Application No: P/86/22/HH
Site Address: Rose Cottage Priors Way Pagham PO21 3JU
Description of works: Single storey front extension, following demolition of existing swimming pool.

Thank you for your internet representation made on 2nd June 2022 which has been recorded as an objection with the comments as follows:

PROPOSED GROUND FLOOR PLAN

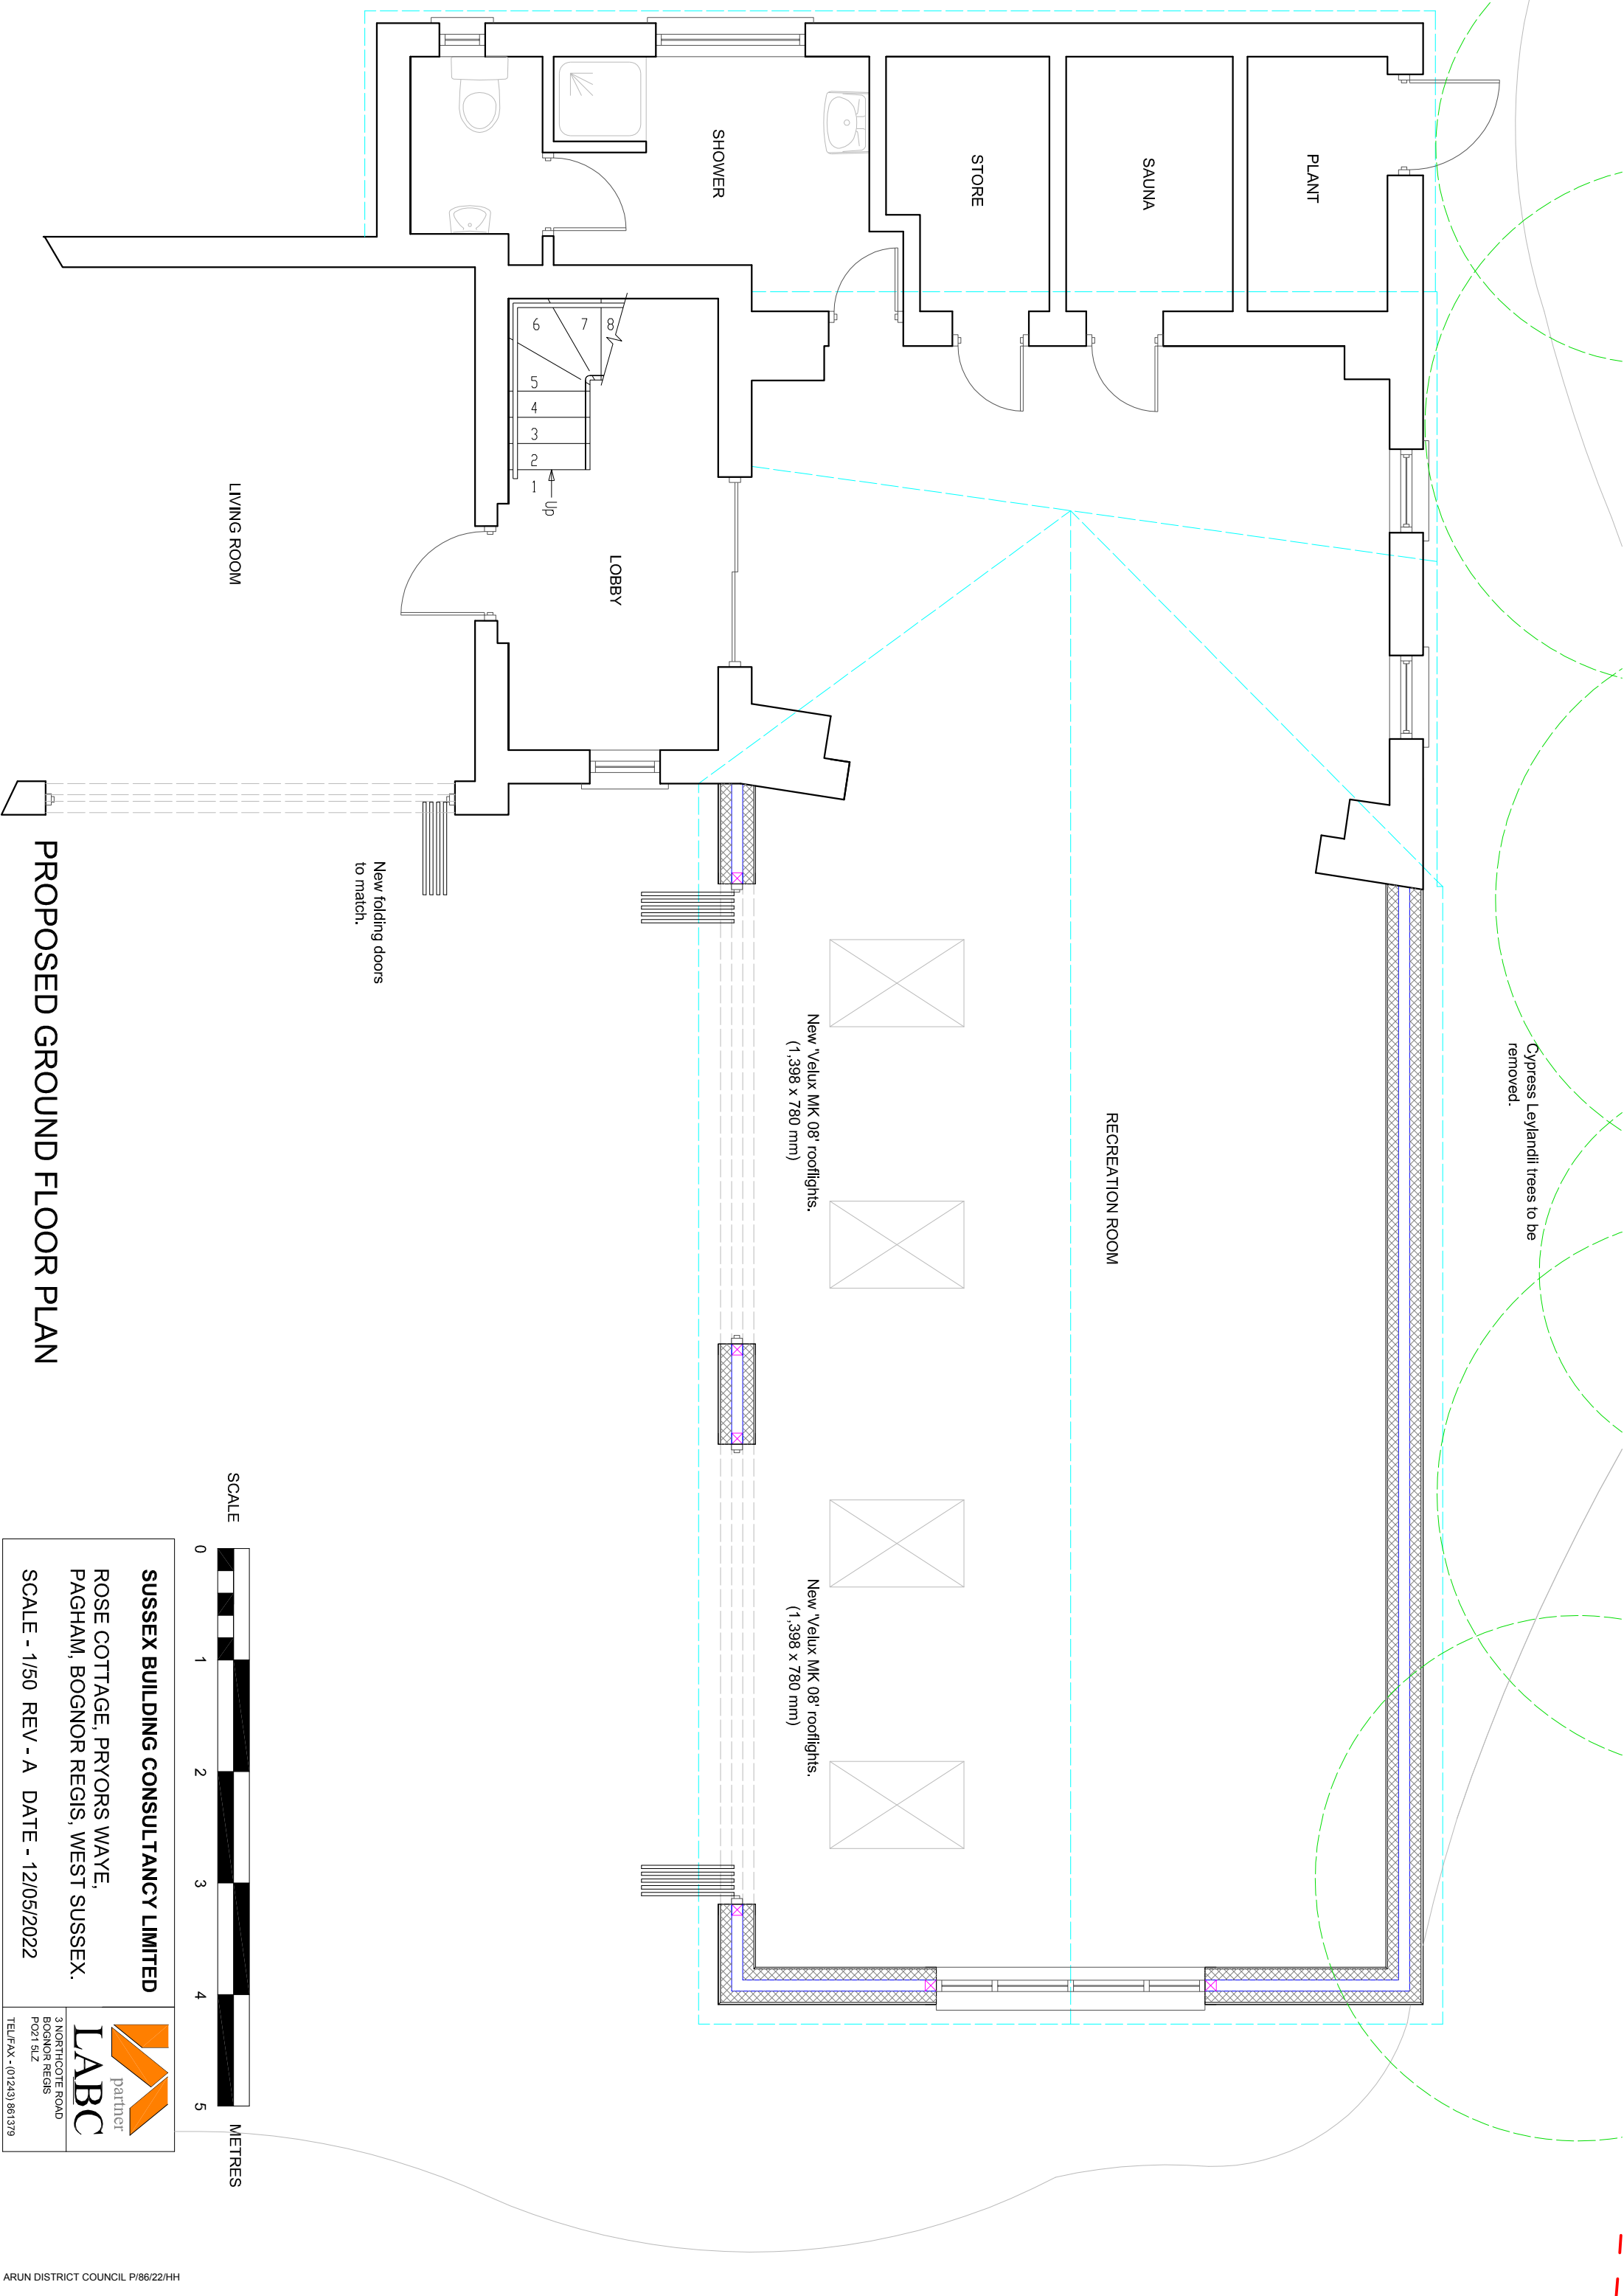
We are very concerned that this single storey extension will further block out the very little sunlight that we get, sunlight is already minimal due to the very tall trees on this property that separate our property from Rose Cottage and already block most of the light into our garden/house.
